Our Ref: A/158/08/

30th January 2009

Erection of 11 dwellings with rear parking court & associated landscaping
Station Road Angmering

Proposed Site Layout @ 1:500

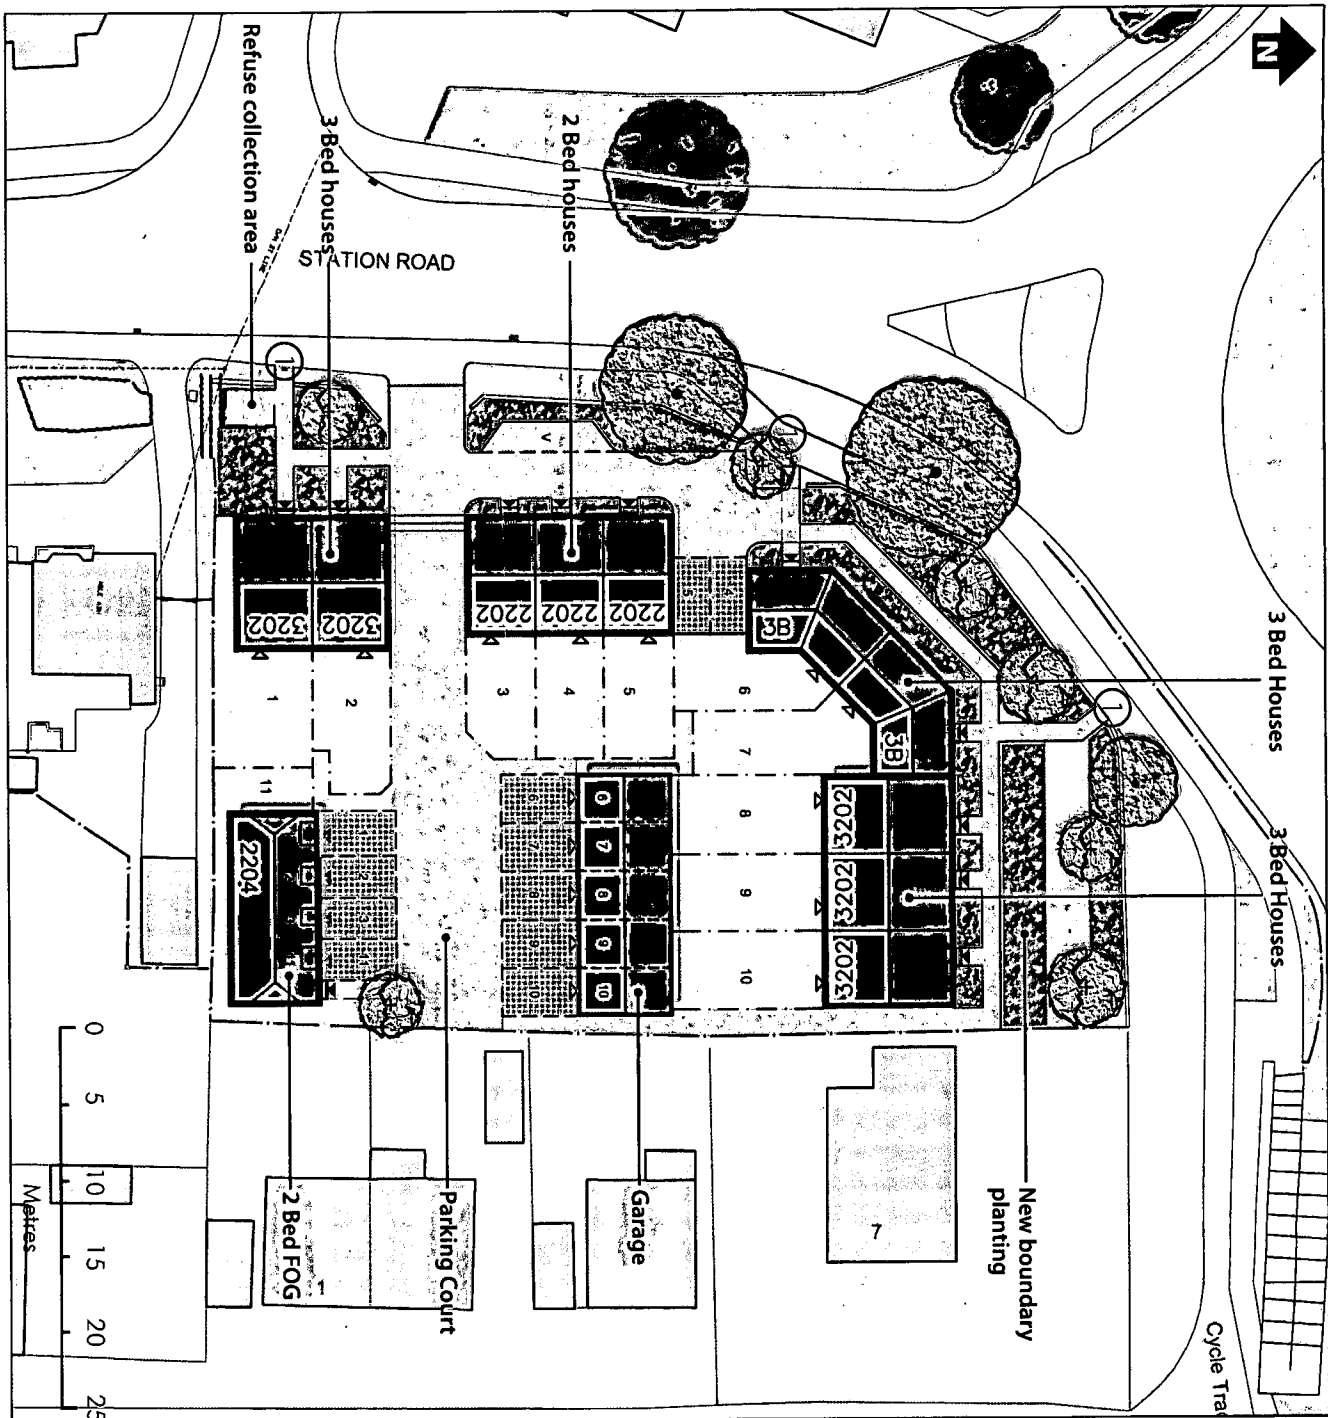
It was agreed that there was no objection in principle, however the Committee were disappointed to find that the number of dwellings proposed falls just short of a number that would provide statutory planning gain. The Committee would query whether the refuse area is adequate for eleven properties.
